From: Sue Howell
Sent: 01 October 2018 15:18
To: Planning.Responses
Cc: Anita Gardner
Subject: RE: Planning Consultation on R/152/18/DOC

Comment from Greenspace

APPLICATION NO: R/152/18/DOC

Description of Works: Approval of details reserved by condition imposed under R/52/16/PL relating to condition 10-landscape scheme.

Layout Plan 1:200

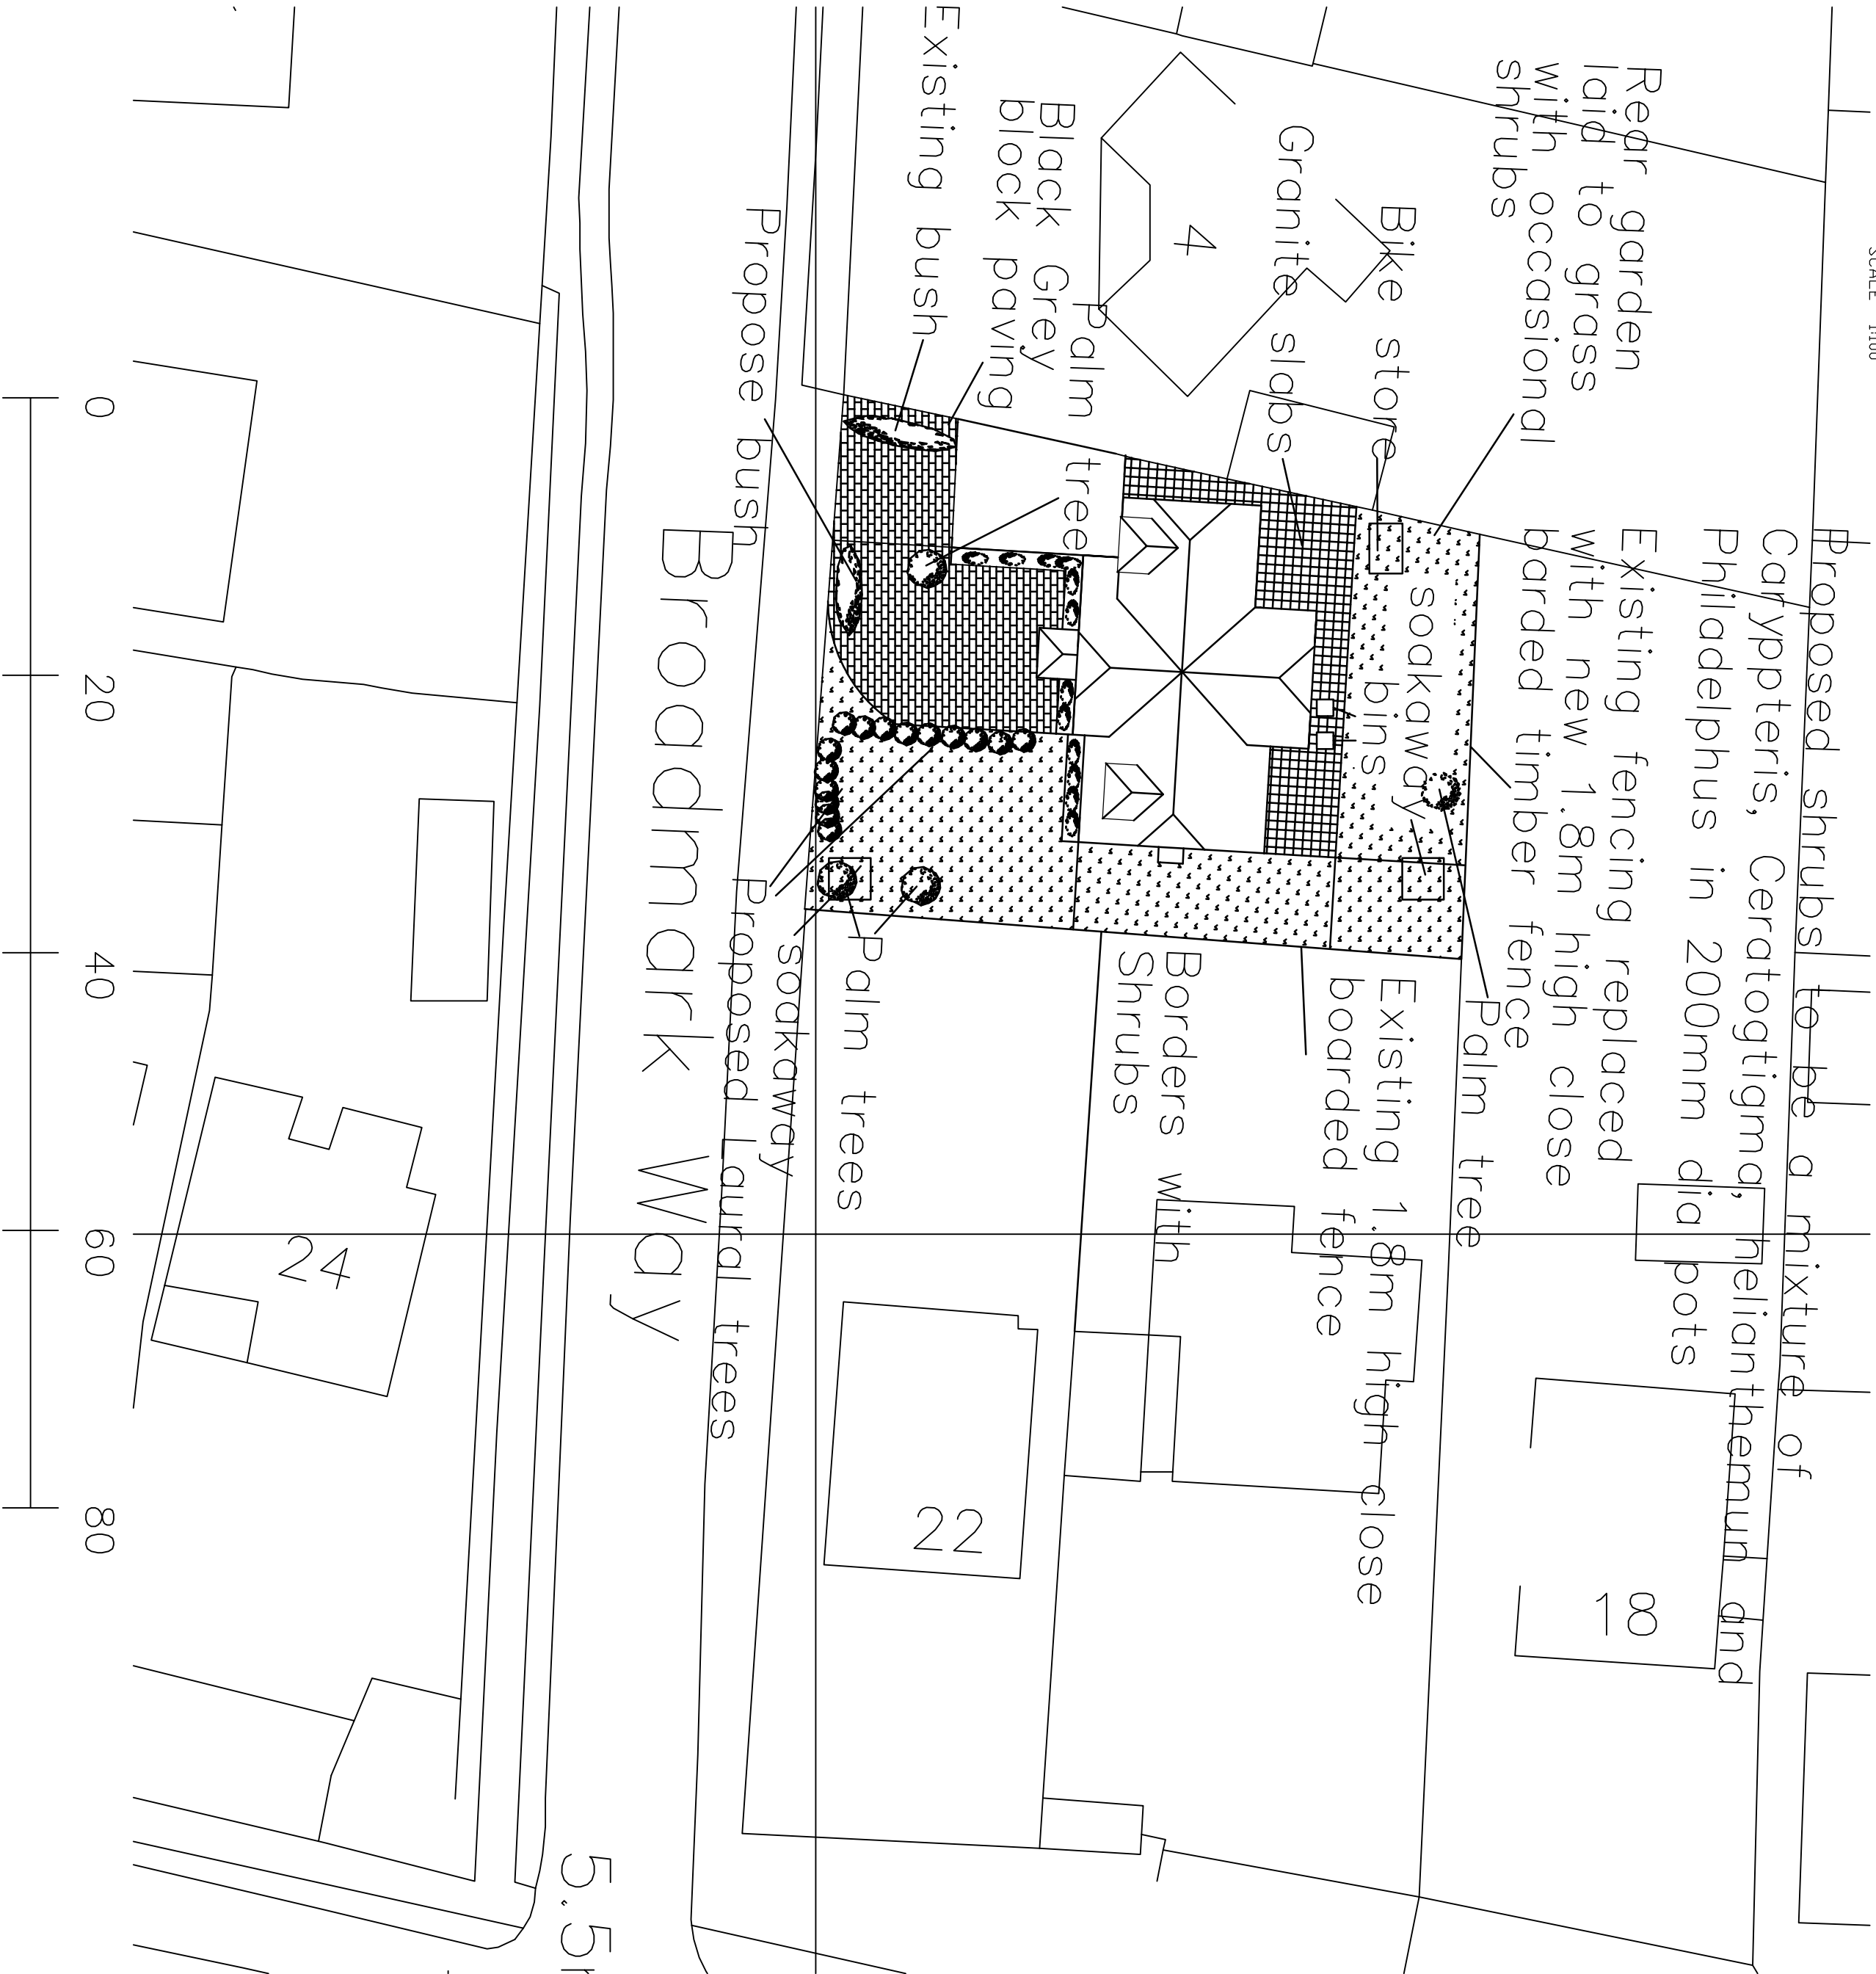
The information submitted in dwg 15/1091/02 rev C has not been supplied in sufficient detail. The landscape planting detail needs to be included in plan form with species choice and actual proposed plant numbers, densities and height at time of planting. The drawings submitted at present are lacking this detail

I would suggest that there is insufficient information submitted and therefore **would not recommend the discharge of Landscape condition 10** imposed under consent R/52/16/PL on this application R/152/18/DOC until this information is submitted.
